Application Ref:	3/2025/0920			 Ribble Valley Borough Council www.ribblevalley.gov.uk				
Date Inspected:	N/A	Site Notice:	N/A					
Officer:	EP							
DELEGATED ITEM FILE REPORT:					APPROVAL

Development Description:	Certificate of Lawfulness for proposed single-storey extension to rear.
Site Address/Location:	34 Bracken Hey, Clitheroe BB7 1LW.

PROPOSED PARTIAL FIRST FLOOR PLAN
Scale 1:50

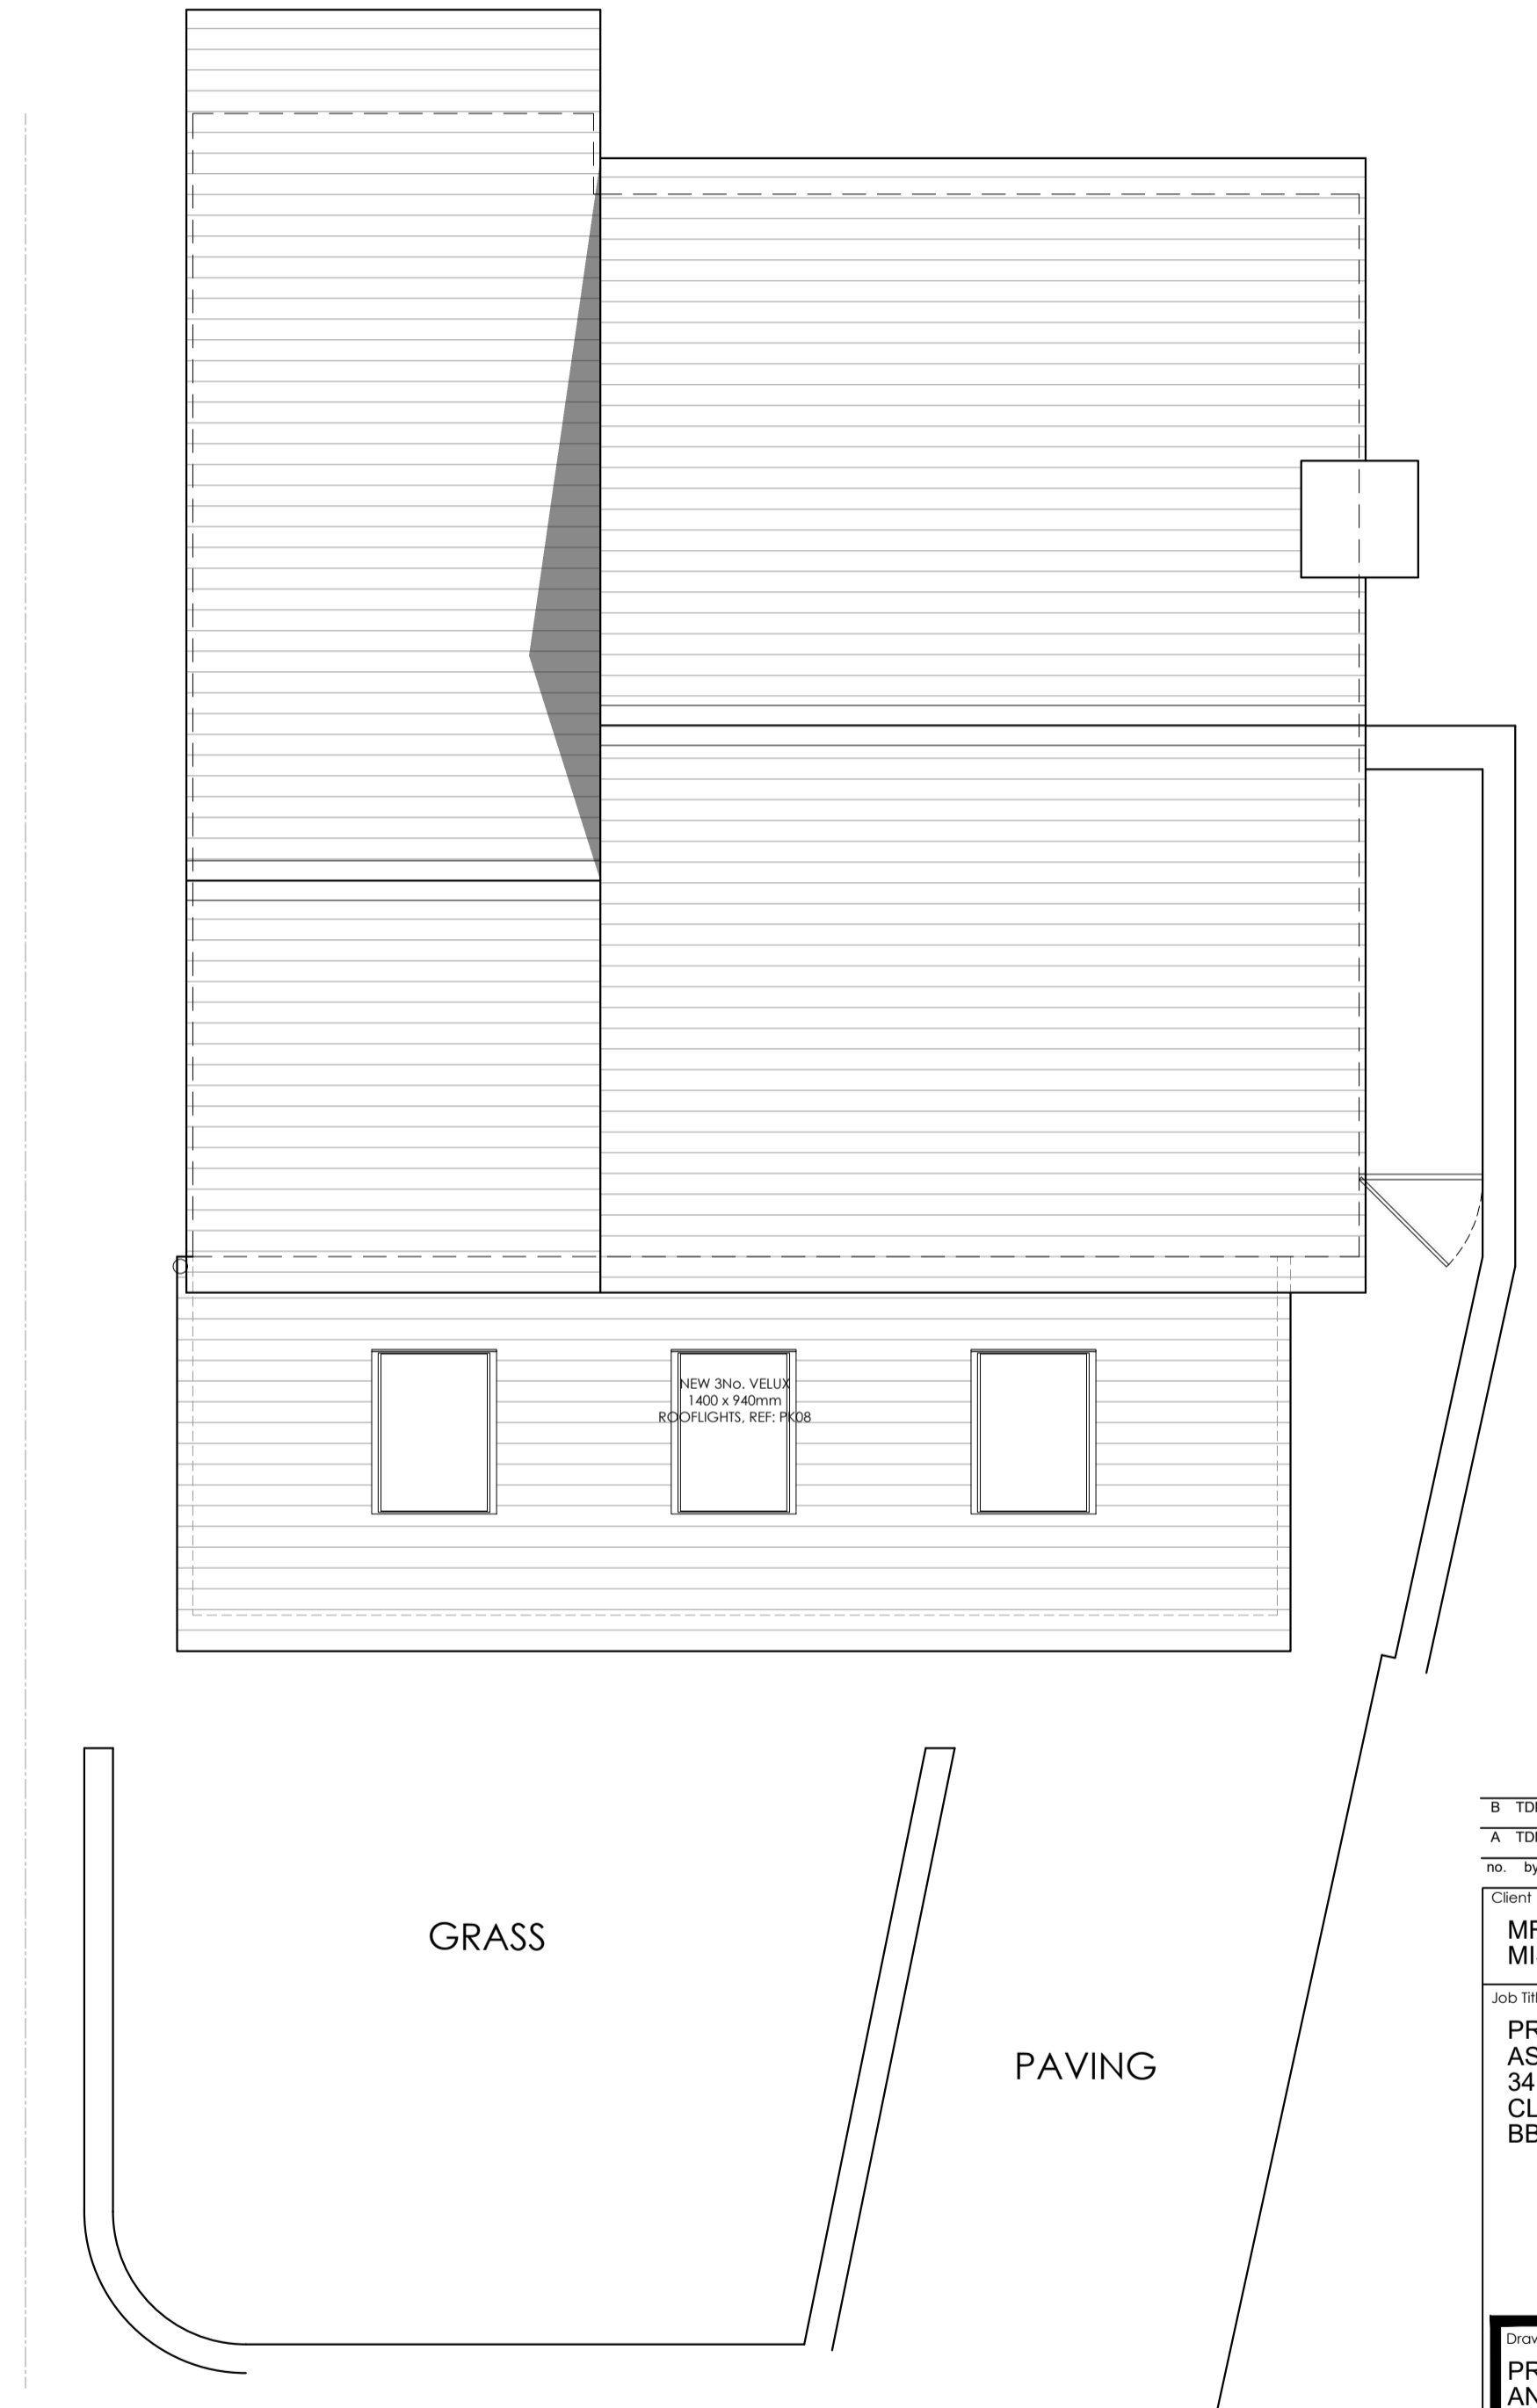
The proposed single storey extension will extend beyond the rear elevation of the dwelling by 2.7m metres and will measure 3.47 metres in height.

The proposed single storey extension will measure 2.67 metres in height to the eaves.

The proposed extension will be constructed in brickwork to the elevations with concrete rooftiles, this is consistent with the application dwelling.

The proposal meets the above criteria to be classed as permitted development.
